From: Joanne Lewis [REDACTED]
Sent: 05 December 2019 15:29
To: Planning.Responses [REDACTED]
Subject: RE: Planning Consultation on M/97/19/DOC

APPLICATION NO: M/97/19/DOC

Site Address: Poultry Farm 87 Yapton Road Middleton-On-Sea PO22 6DY

Description of Works: Approval of details reserved by condition imposed under ref M/45/16/PL relating to Condition No 18 - Construction Management Plan

16. Site Plan and Associated Drawings/Photographs

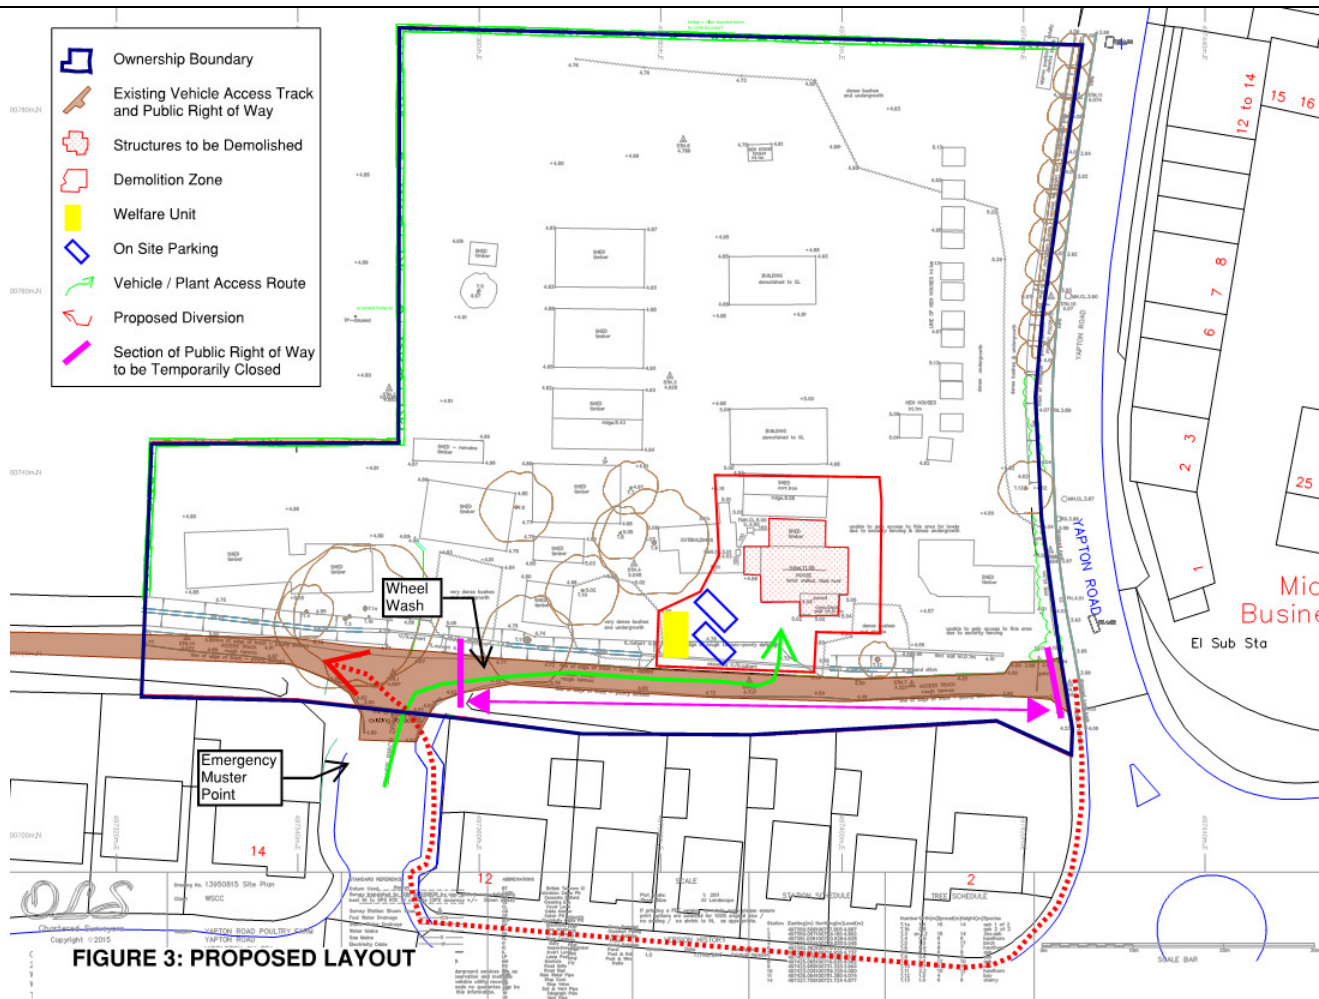
The demolition method statement is acceptable however I would prefer to see solid hoarding at the boundary with neighbouring residential properties in order to offer them greater protection from noise and dust from the demolition.
